**From:** Brenda Larsen  
**Sent:** Tuesday, January 06, 2015 12:21 PM  
**To:** Jeff Watson  
**Subject:** RE: BL-03-04150 Plum Creek

Re: Plum Creek (BL-03-04150)

After conducting a review of the recent changes to the above named project, I have the following comments:

BOUNDARY LINE ADJUSTMENT RECORD OF SURVEY

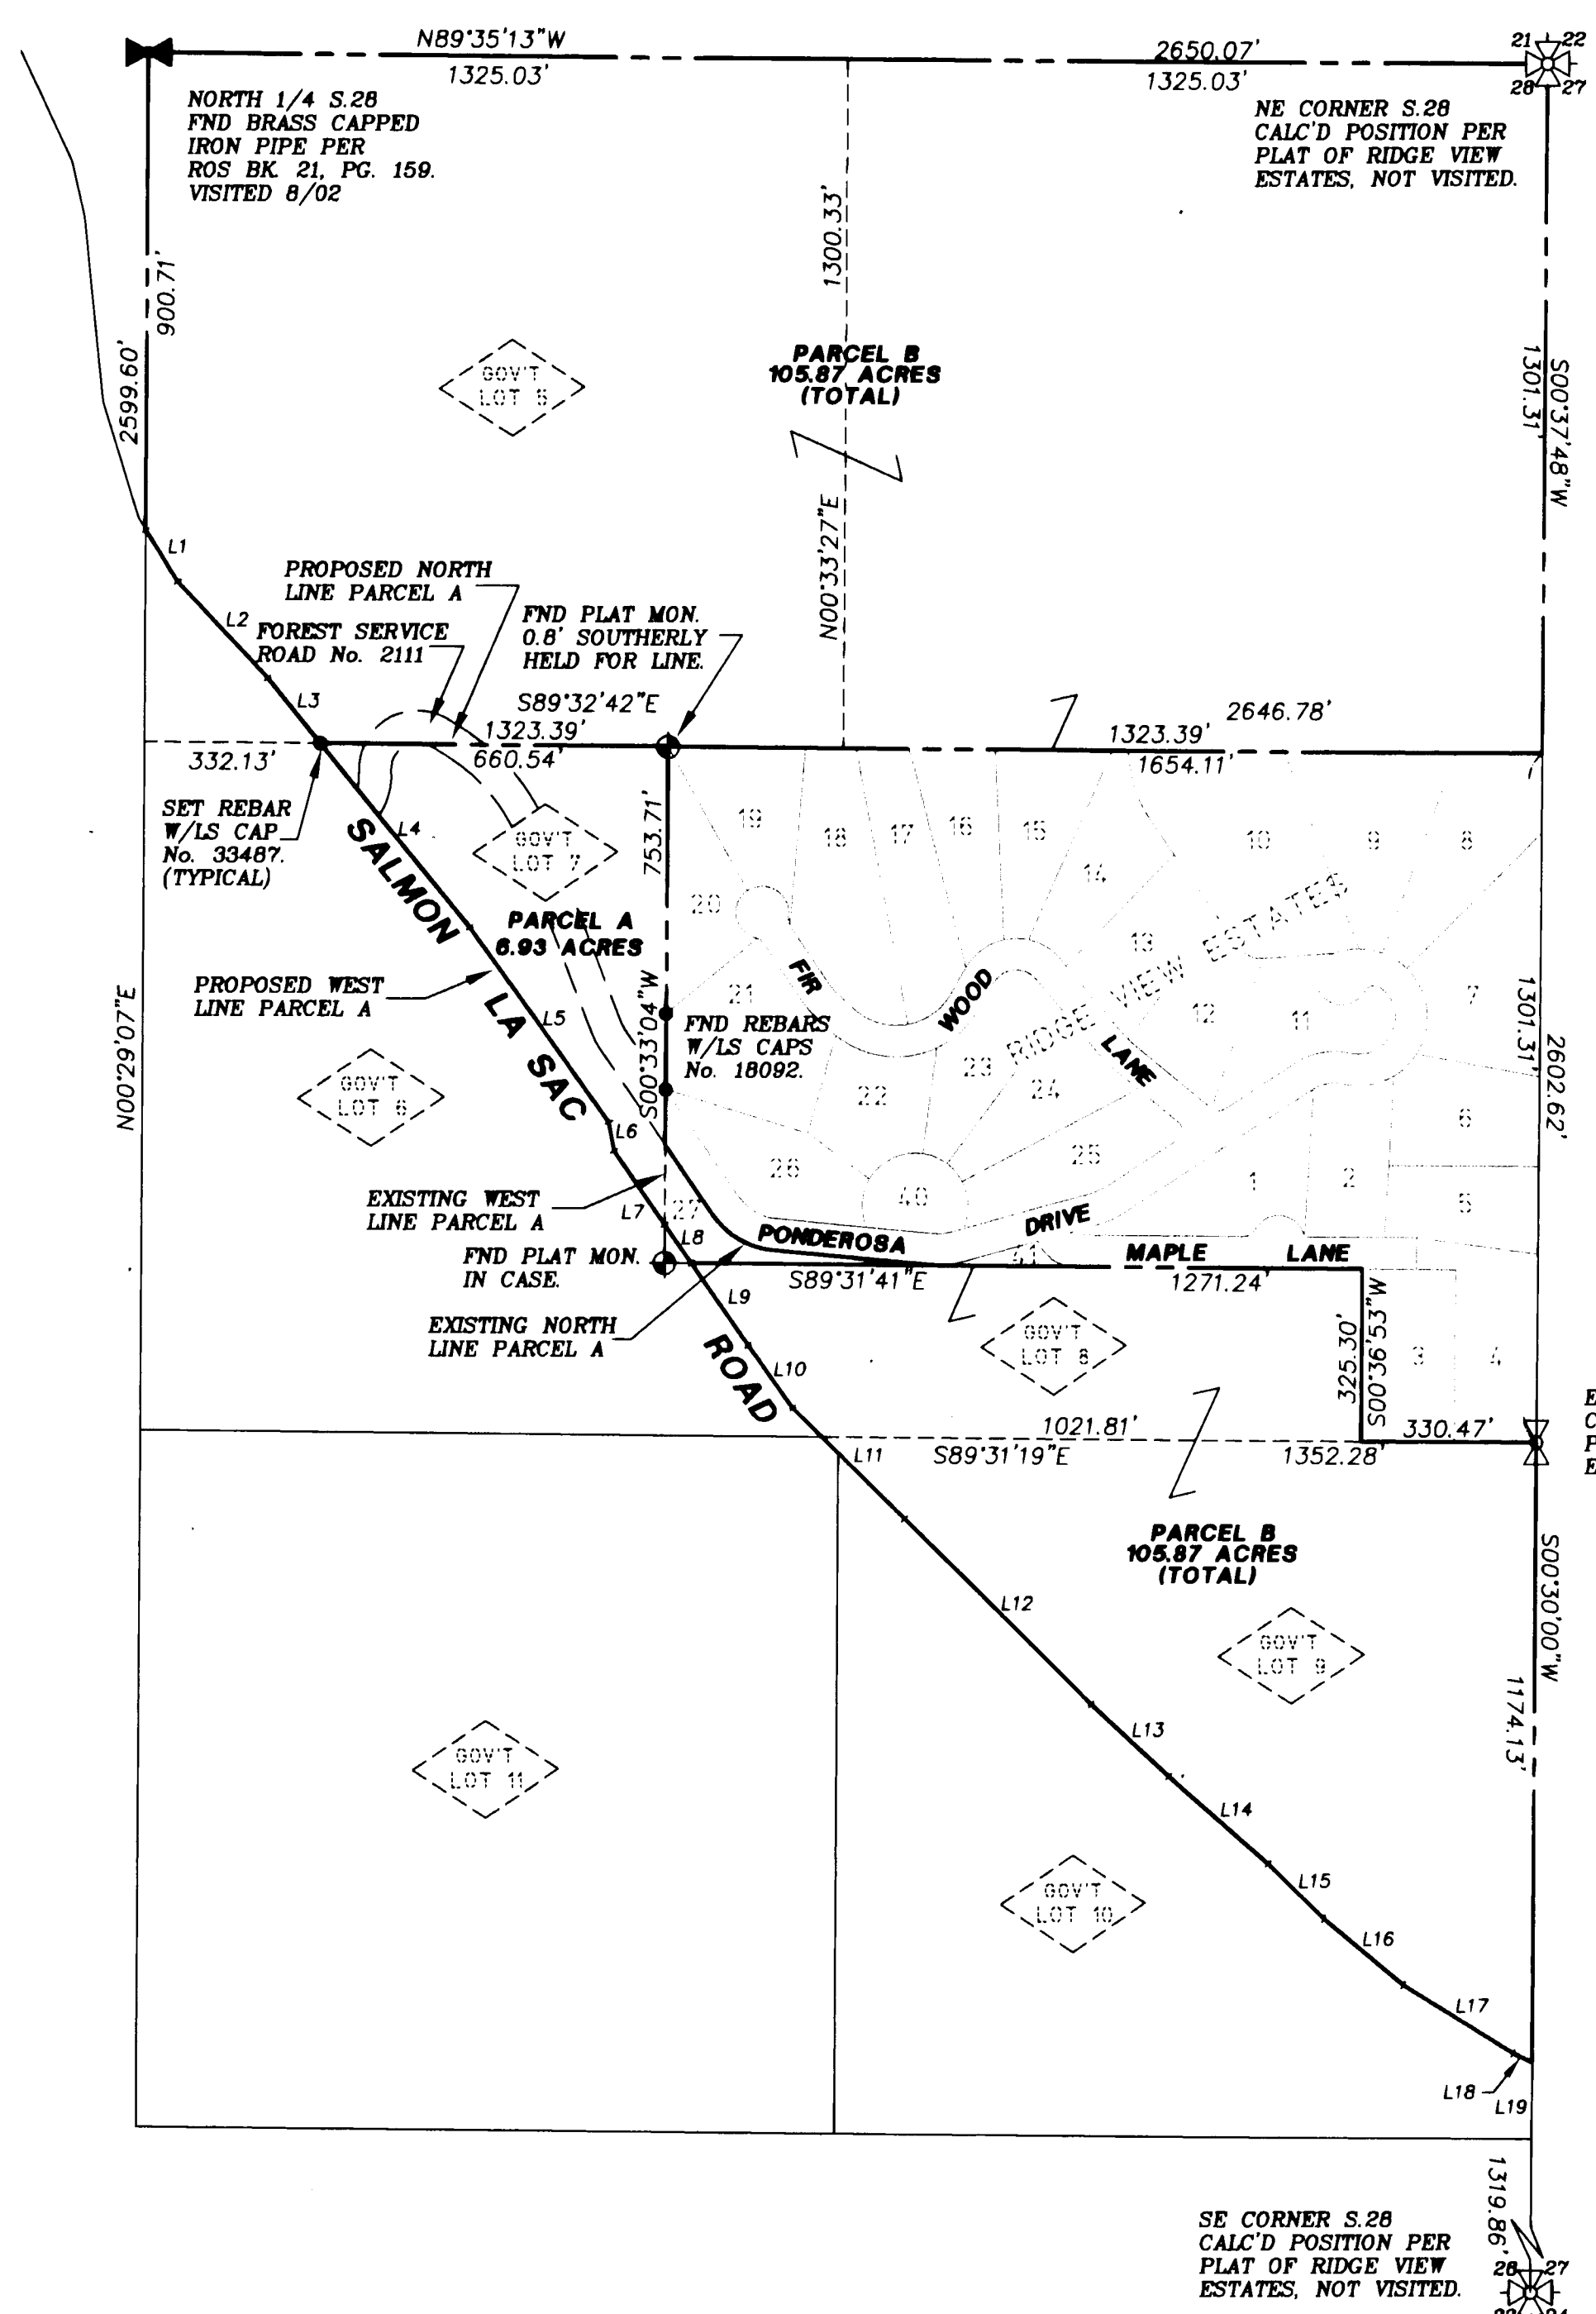
- Ensure that boundary line adjustments do not infringe upon existing structures, to include propane tanks, etc.
- Ensure adequate access for fire apparatus. Any driveways or access points created based off the new lot configurations shall comply with Kittitas County Code 20.02.030.
- All future development must comply with the International Fire Code.
